**WELWYN HATFIELD BOROUGH COUNCIL
EXECUTIVE DIRECTOR - PLANNING, PUBLIC PROTECTION AND GOVERNANCE**

Application No: 6/2020/1636/FULL
Location: 143-153 Longcroft Lane Welwyn Garden City AL8 6EL
Proposal: Replace of windows with uPVC
Officer: Mrs Sarah Madyausiku

6/2020/1636/FULL

Drawing Title:  
**Block 4 - Proposed  
Front, Side & Rear Elevations**

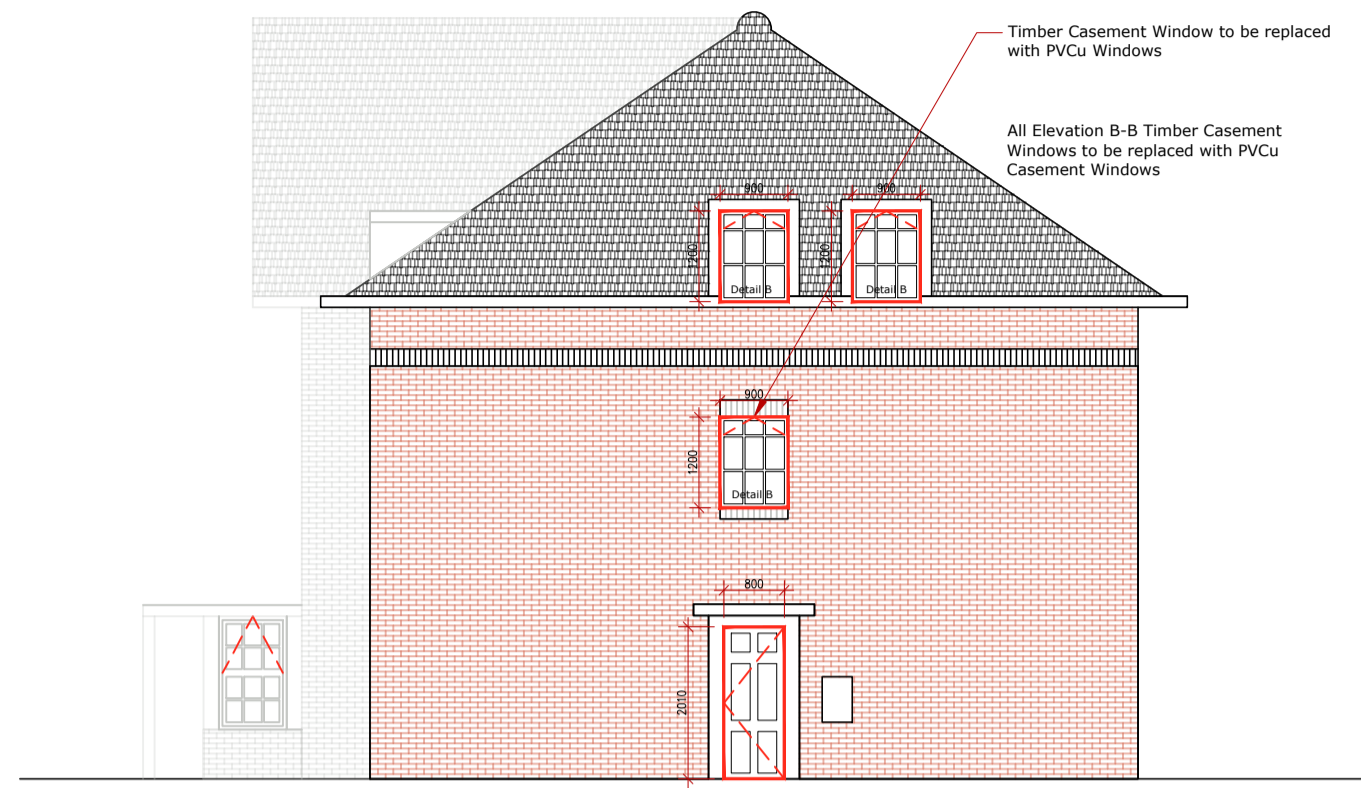
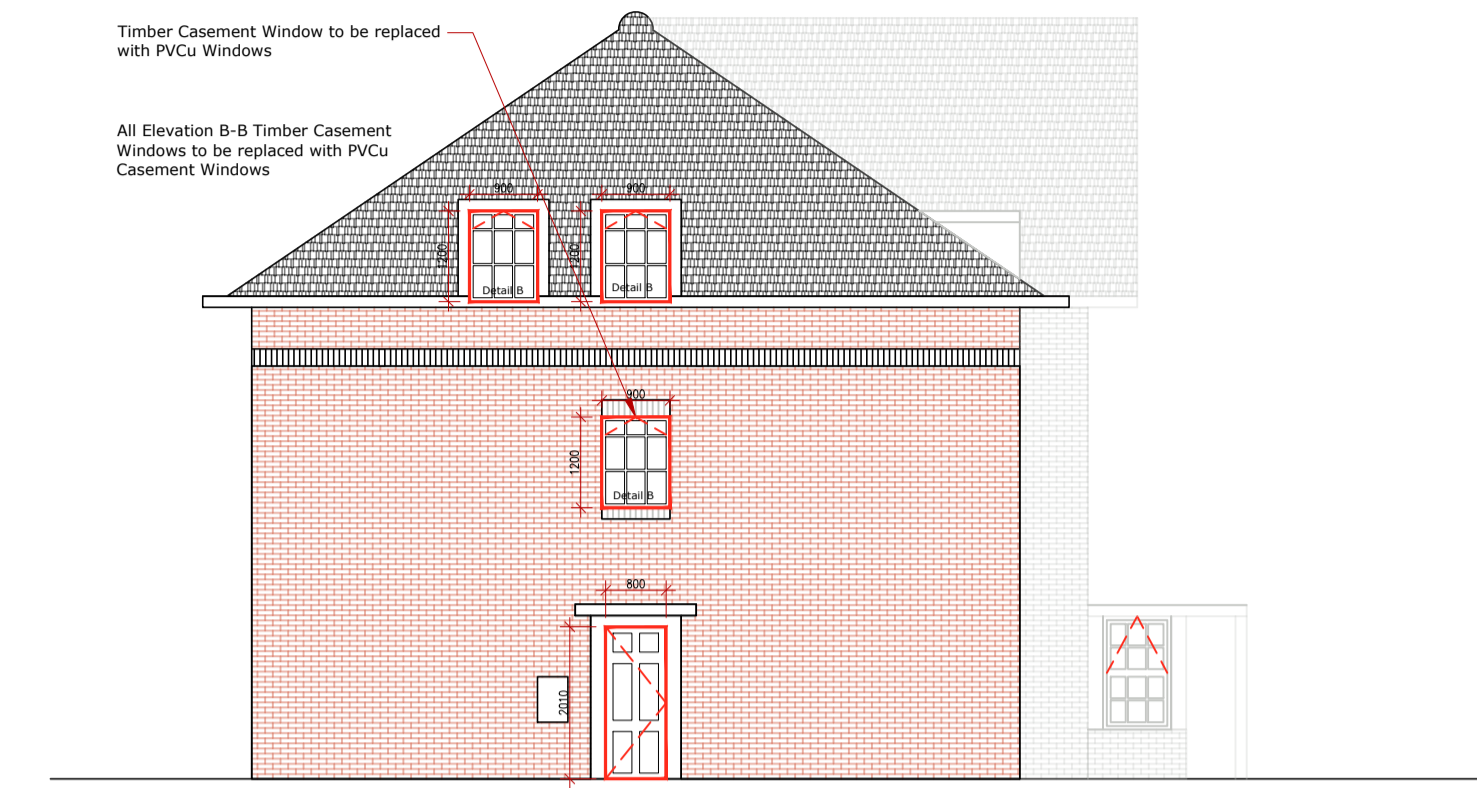
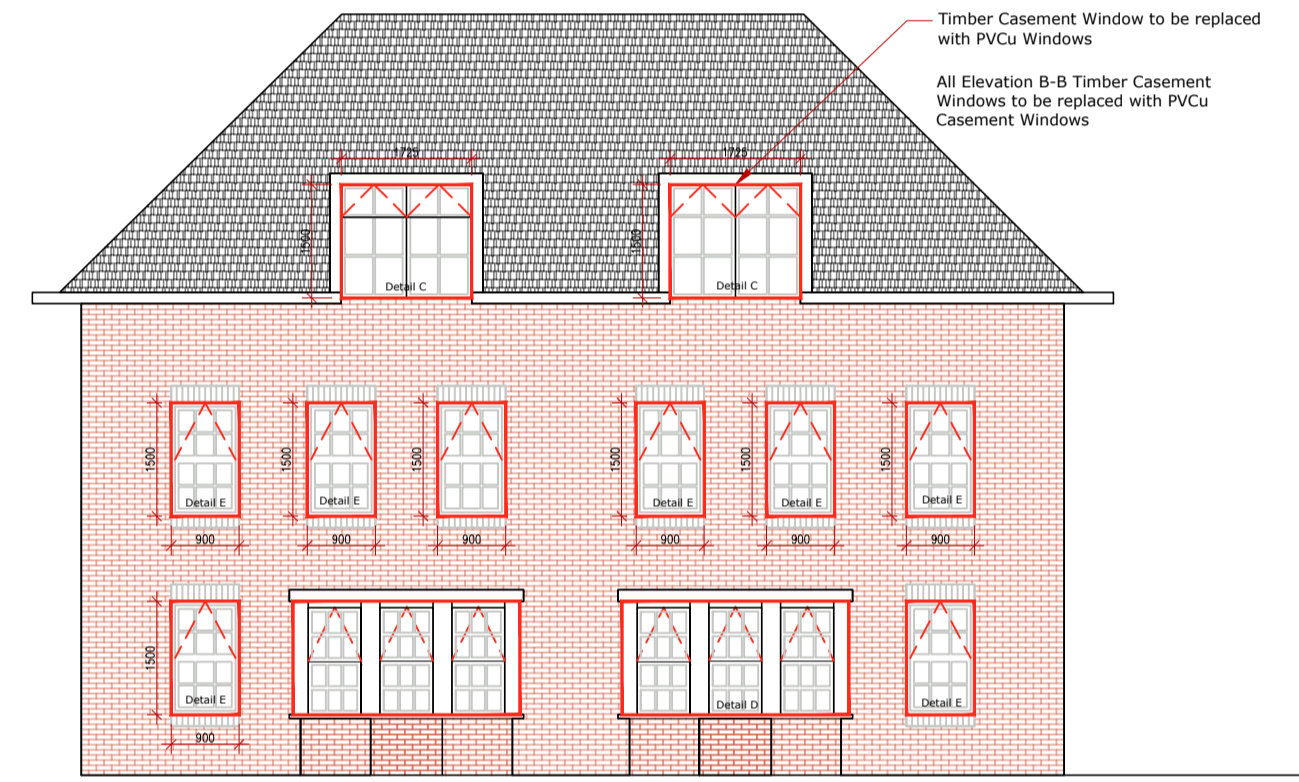
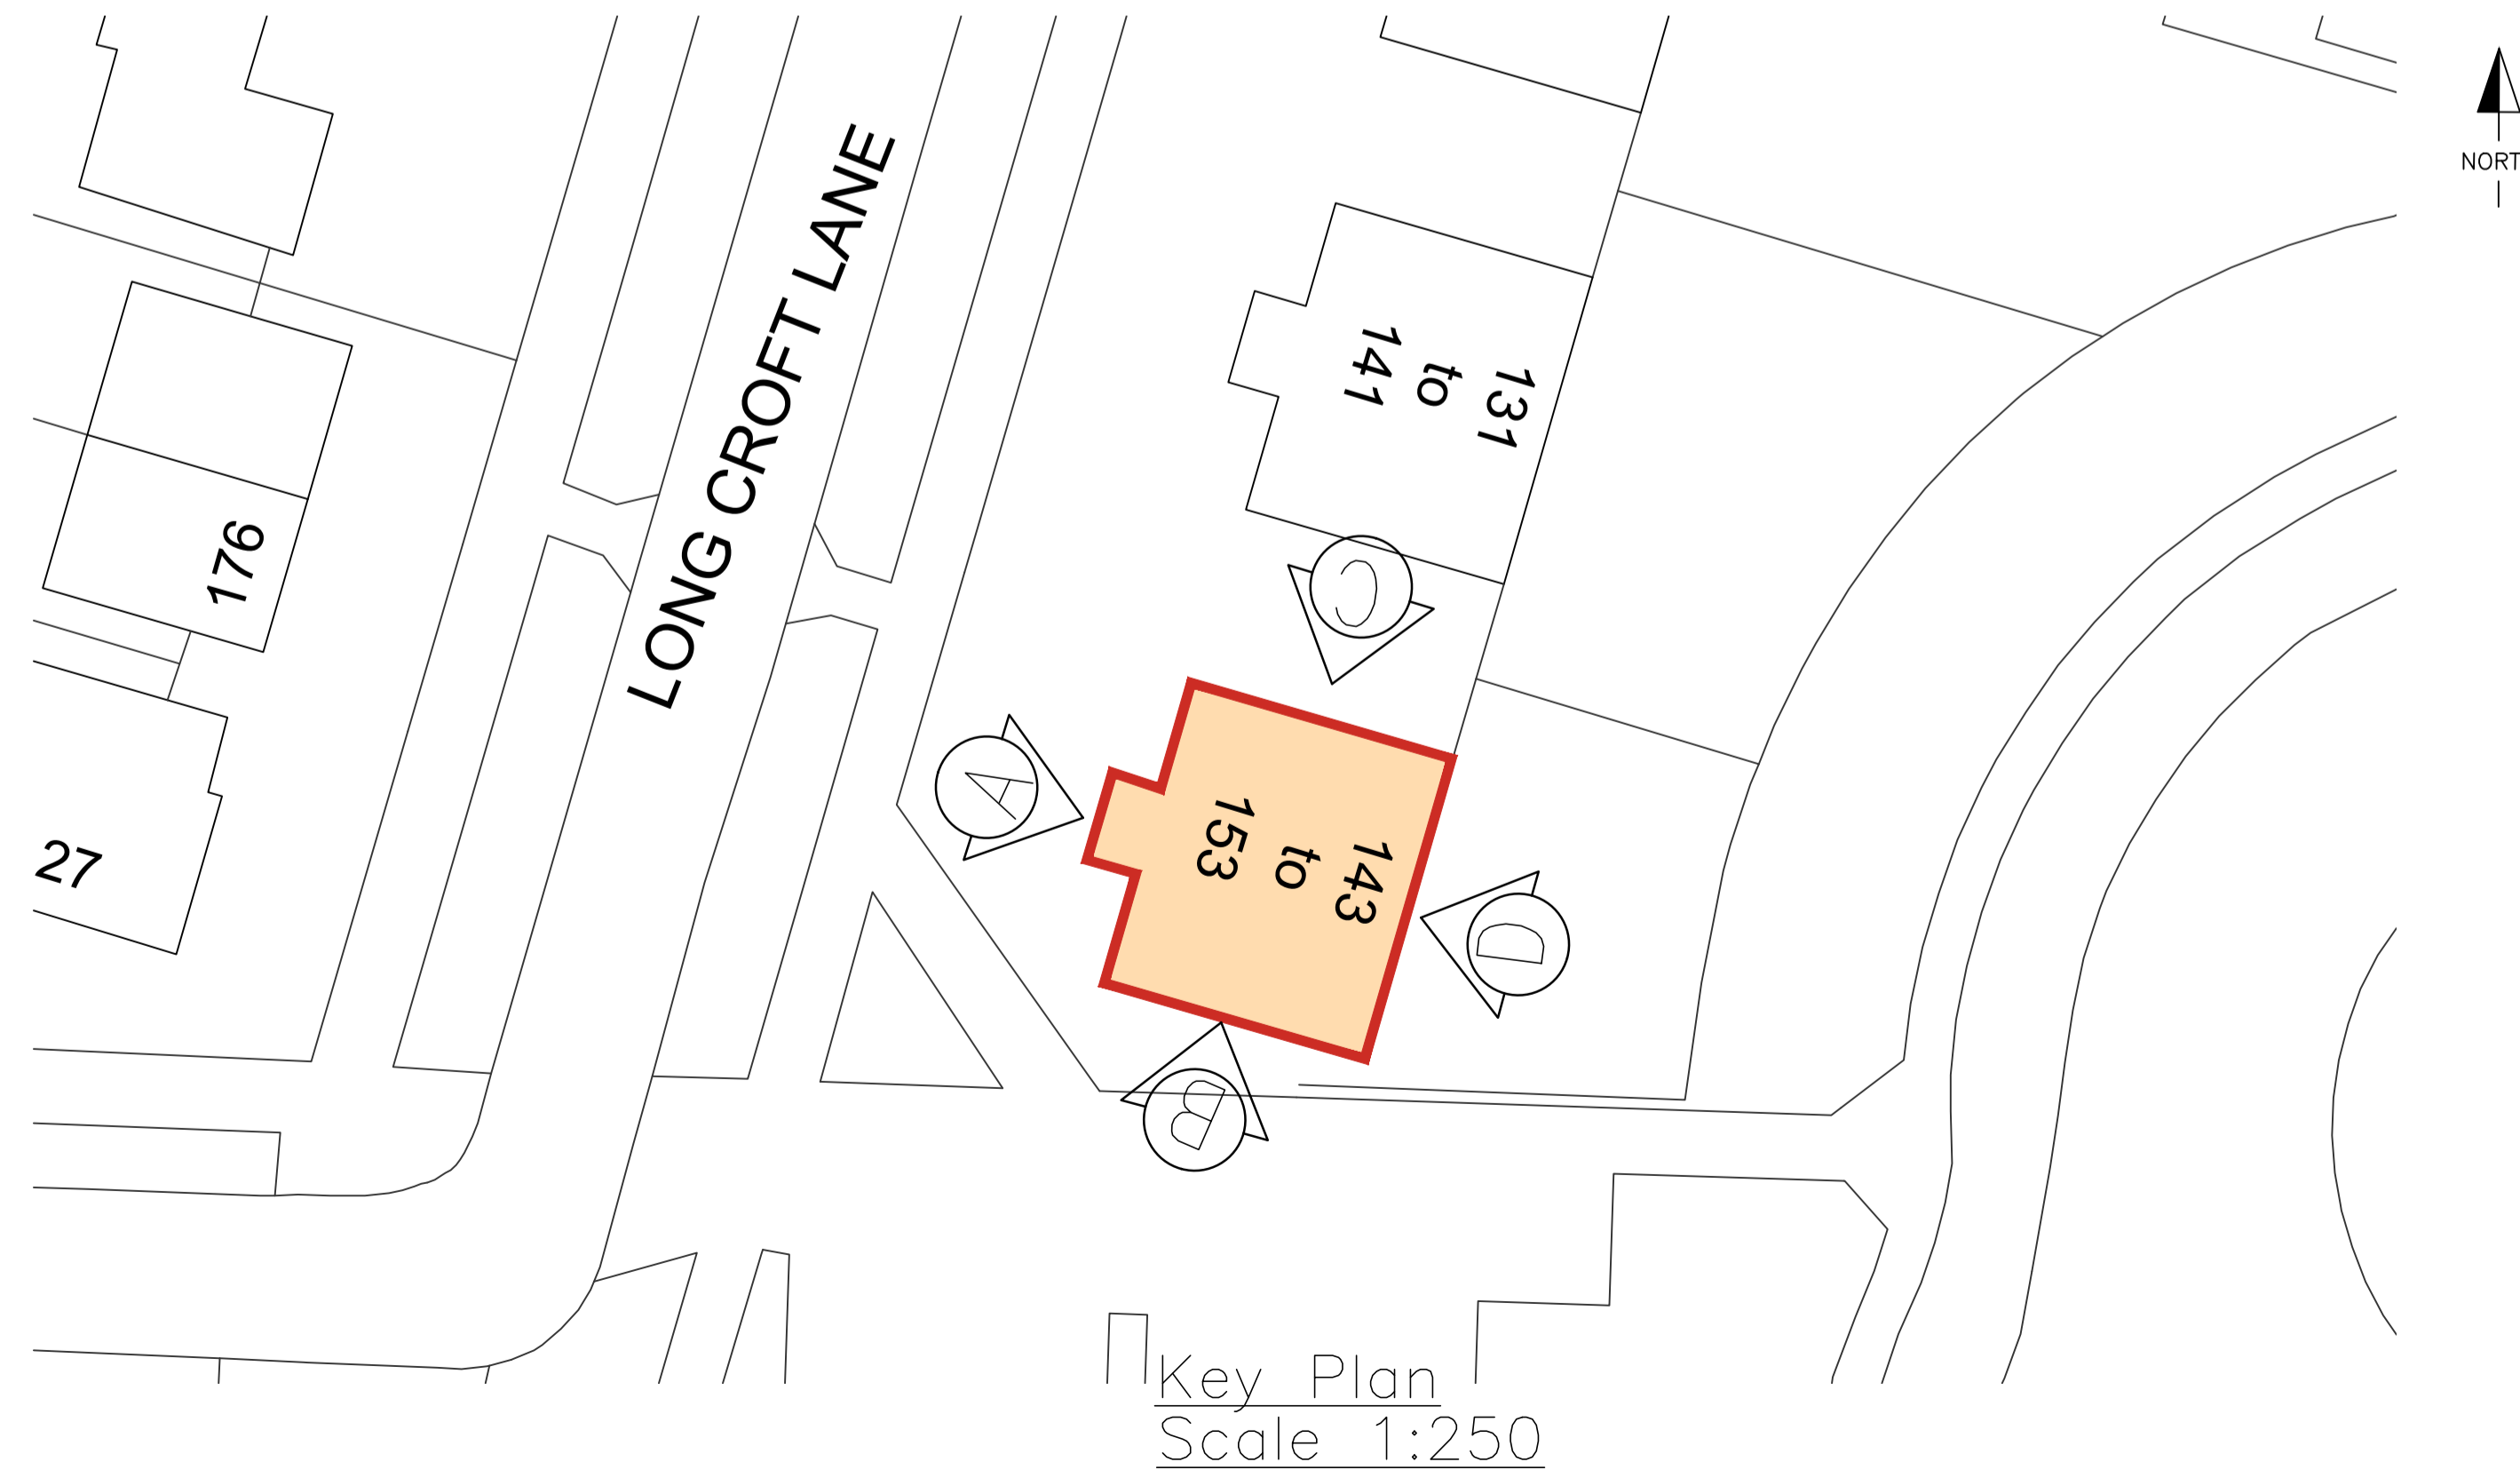
| Context | | | |
|--|--|-----------|----------|
| Site and Application description | The application is for the replacement of the existing double-glazed timber top hung casement windows to the block of flats that incorporate 143-153 Longcroft Lane. The windows would be replaced with double glazed uPVC windows to match the existing styles of the existing timber units. | | |

| <input checked="" type="checkbox"/> Yes <input type="checkbox"/> No Comment (if applicable): <p>The development is located within the Welwyn Garden City Conservation Area. It should be noted that Section 72 of the Listed Buildings and Conservations Areas Act (1990) states that '<i>special attention shall be paid to the desirability of preserving or enhancing the character or the appearance of that area</i>'. Section 16 of the NPPF 'Conserving and enhancing the historic environment' is broadly consistent with Policy SADM15 'Heritage' of the Emerging Local Plan. Also of relevance, and consistent with the NPPF, are Policies D1 and D2 of the adopted Welwyn Hatfield District Plan (2005) which seek to provide a good standard of design in all new development and require that all new development respects and relates to the character and context of the area in which it is to be sited. These policies are expanded upon in the Council's Supplementary Design Guidance (SDG) which requires that residential extensions should be complementary in design and be subordinate in size and scale to the existing dwelling.</p> <p>The proposed window replacements would not harm the character and appearance of the conservation area. Many of the residential houses within the immediate vicinity have got uPVC windows so this development would not be uncharacteristic. The fenestration pattern would remain of similar appearance so the change of material only would be in keeping with the surrounding streetscene.</p> <p>The application form states that the replacement windows would be white in colour. In order to preserve the character and appearance of the conservation area, a condition is recommended to ensure the replacement windows are white.</p> | |

1. The external window frames, glazing bars, sills, other external decorations associated with the fenestration hereby approved shall not be any colour other than white.
